Comments on Revised Plan for Development of Land next to Ford Road

Planning ref: AB/135/20/OUT

from Alison Wilkinson, 28 Dalloway Road, Arundel, BN18 9HW

Design and Access Statement – Addendum Responding to Section 2 of the Arun Design Guide SPD

View 8 - Western portion of Priory Lane

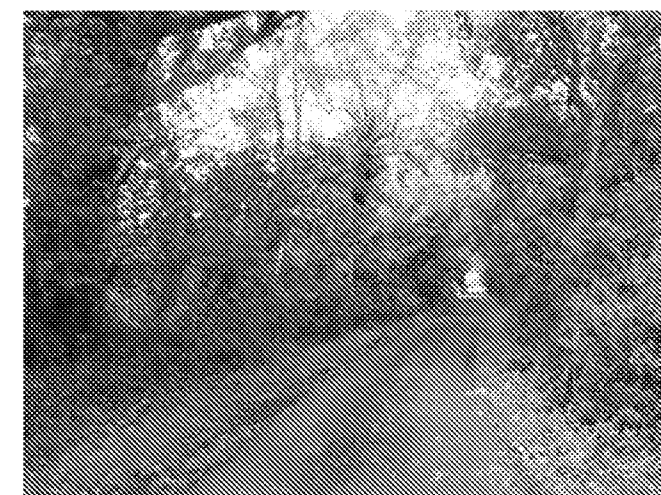
Comment: This clearly shows the unsuitability of such a narrow road for accommodating the excessive amounts of traffic that will occur from people living on the new development cutting through from Chichester to the Ford Road from the A27. This road, during heavy rainfall, is almost impassable and is of single vehicle width. Video and photographs of the road following moderate rain fall are available should further confirmation to support the unsuitability of this road be needed.

Illustrative Masterplan

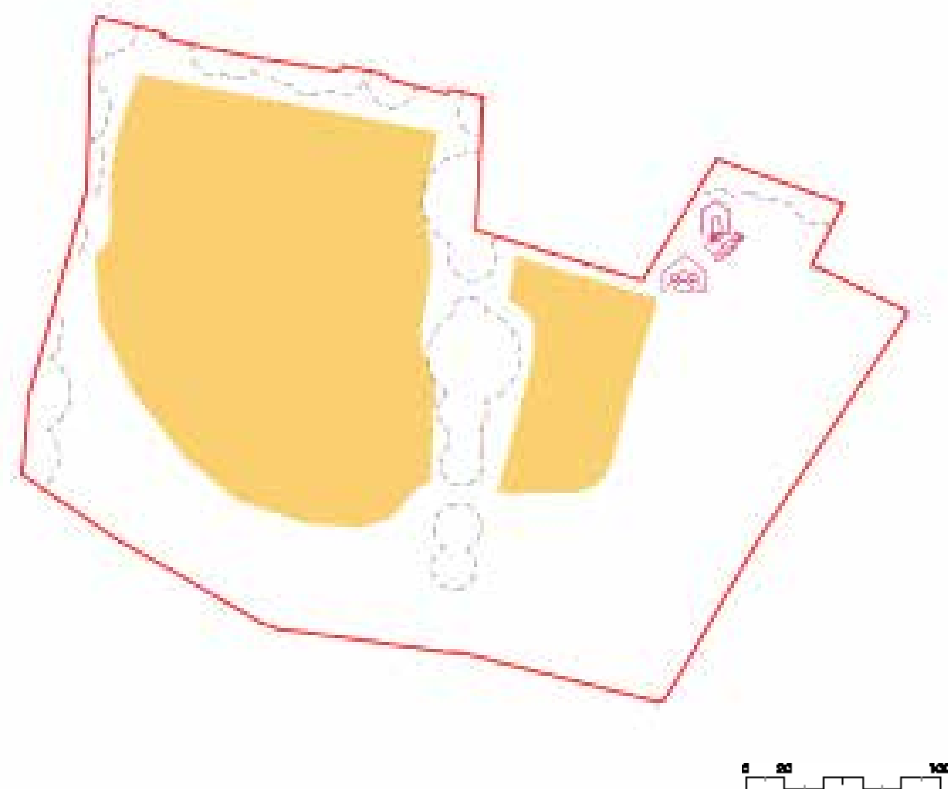
Comment. The revised illustrative master plan now shows not only a community centre but community allotments next to the Priory Road entrance. Does this mean the existing allotments are to be sucked up into the new development or is this in addition to them?
